CHARLOTTE - MECKLENBURG
PLANNING COMMISSION

INTER - OFFICE COMMUNICATION

DATE: July 17, 2007

SUBJECT: Administrative approval for Petition No. 2006-04 by Terri and Stephan McGirt.

SCHEMATIC SITE PLAN
 SHEET SSP 1
 ORIGINAL SUBMITTAL 07/05
 REVISION 07/06
 REVISION 07/06
 REVISION 07/06
 REVISION 07/07

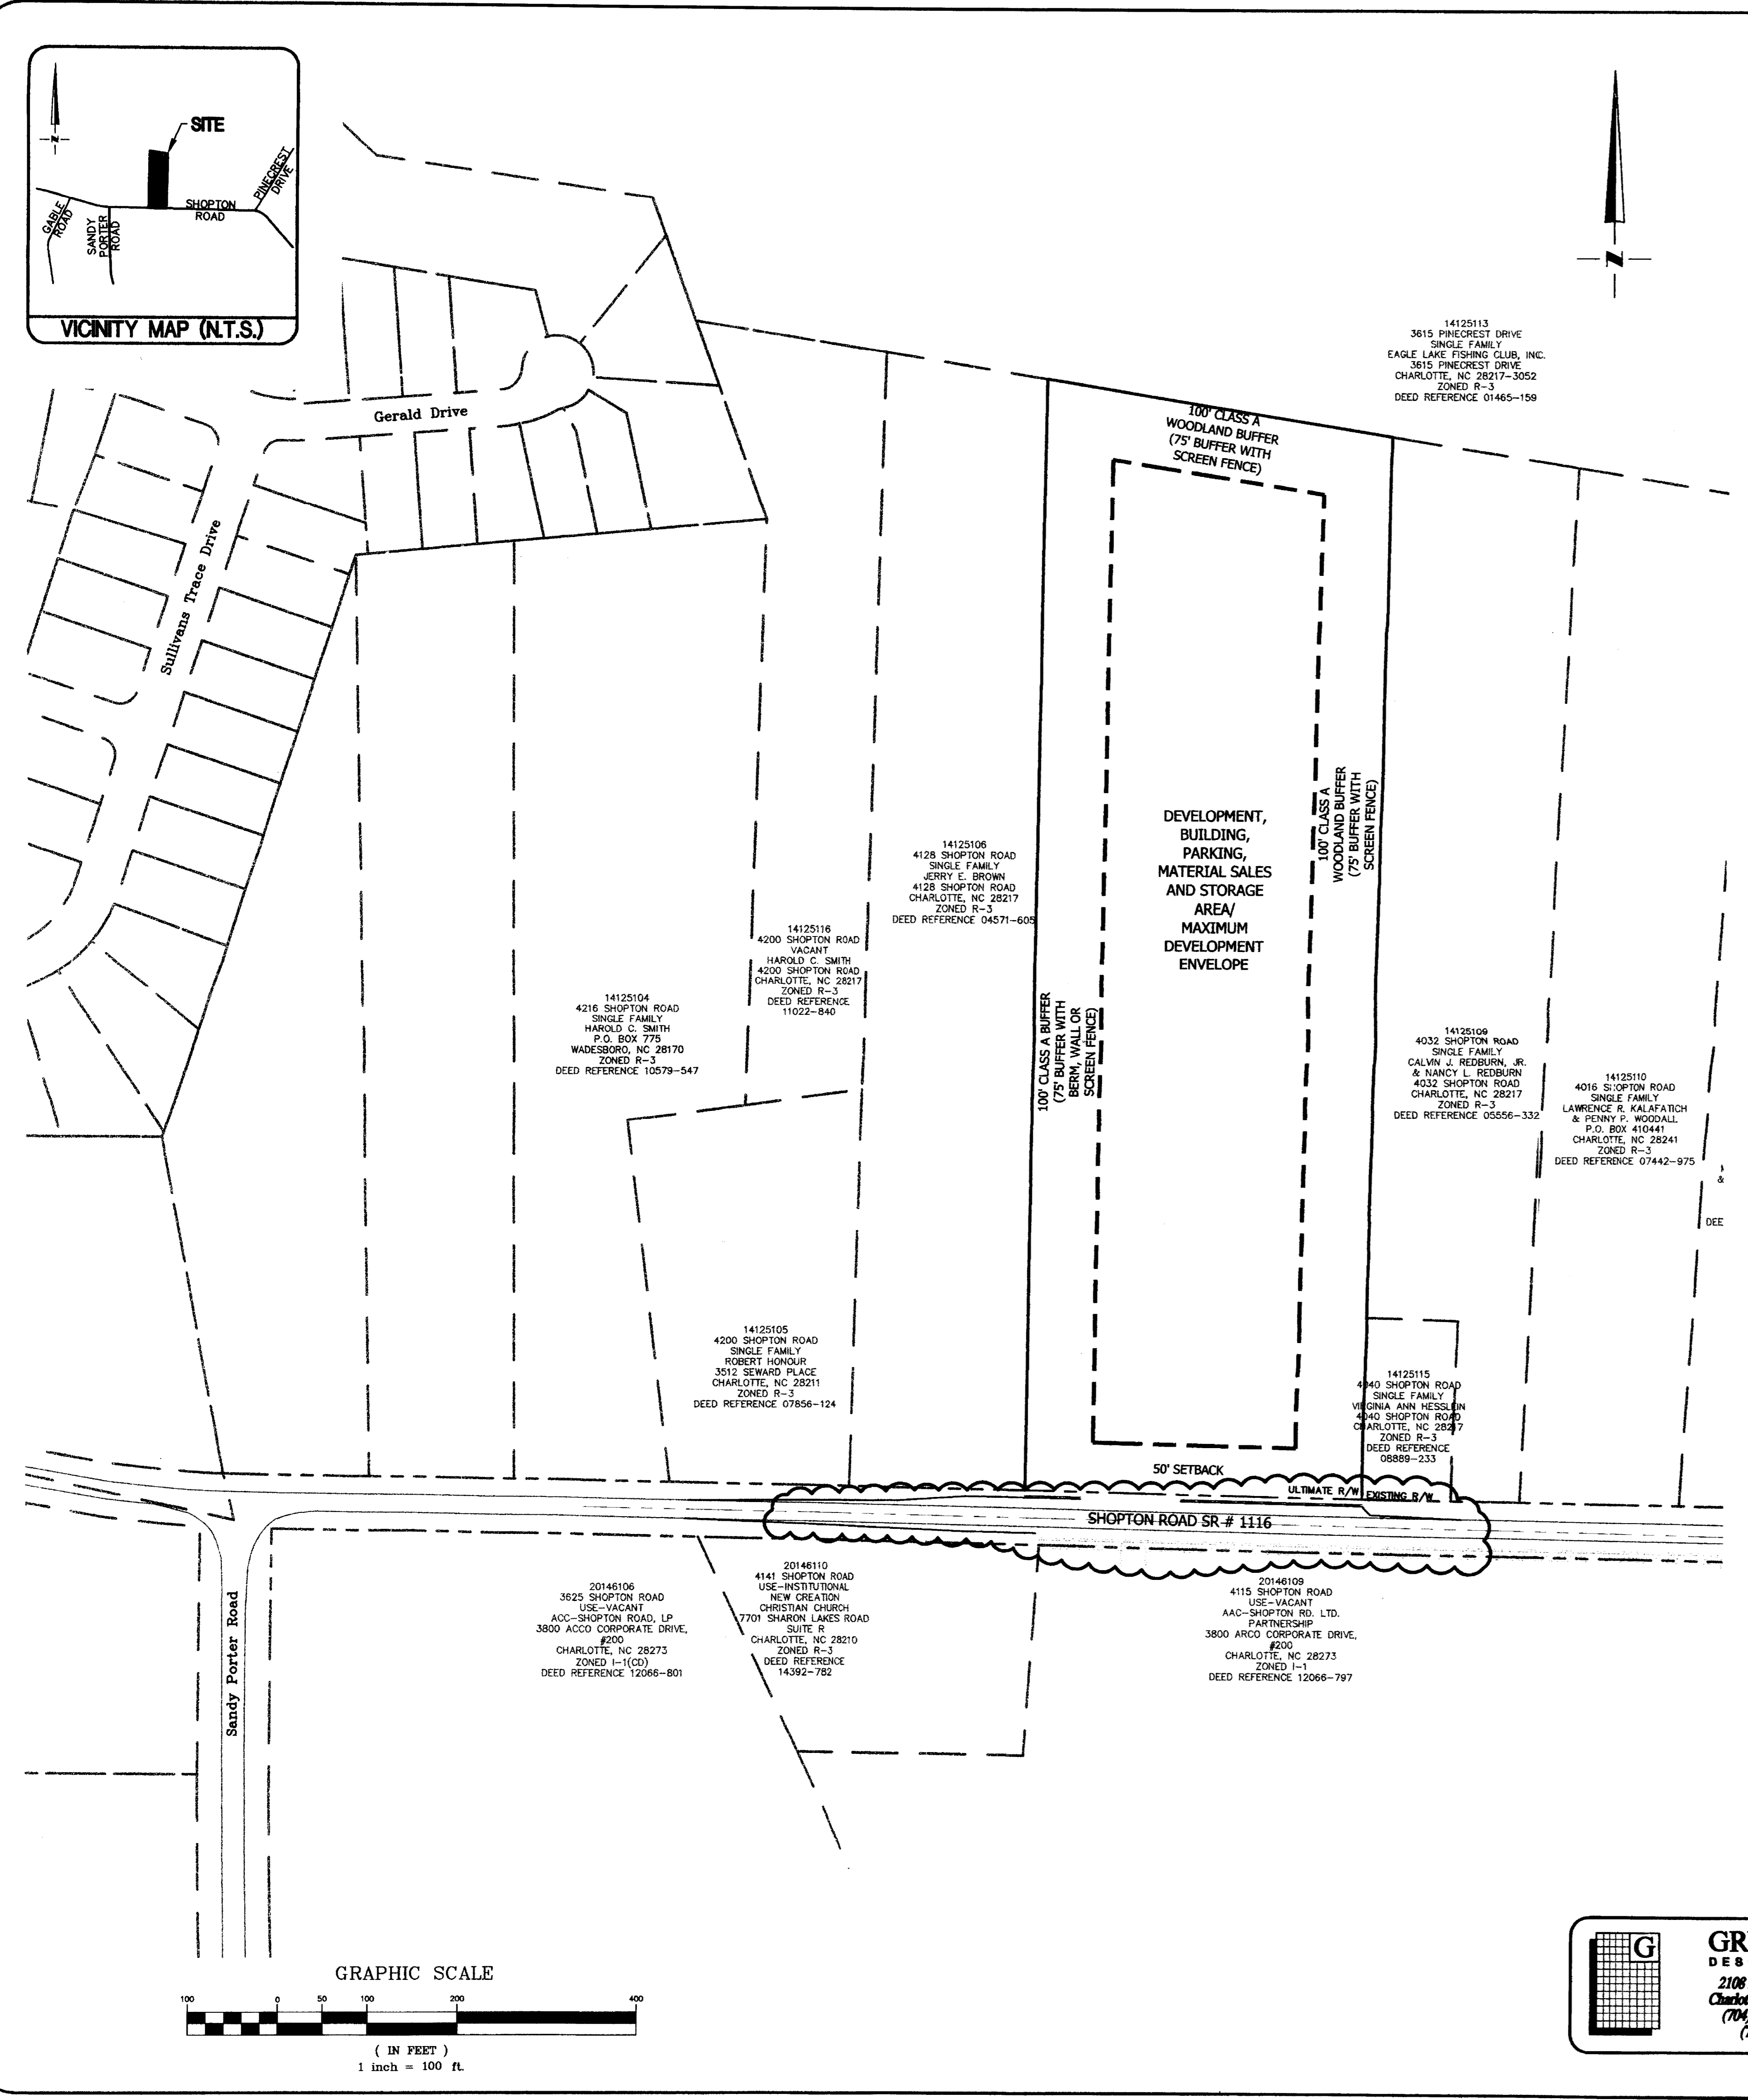
Attached are revised plans for the above petition. The plans have been revised to show a minor change to the site layout. The warehouse will now be part of the office building. Since this is a minor change, I am administratively approving these revised plans. Please use these attached plans when evaluating requests for building permits and certificates of occupancy.
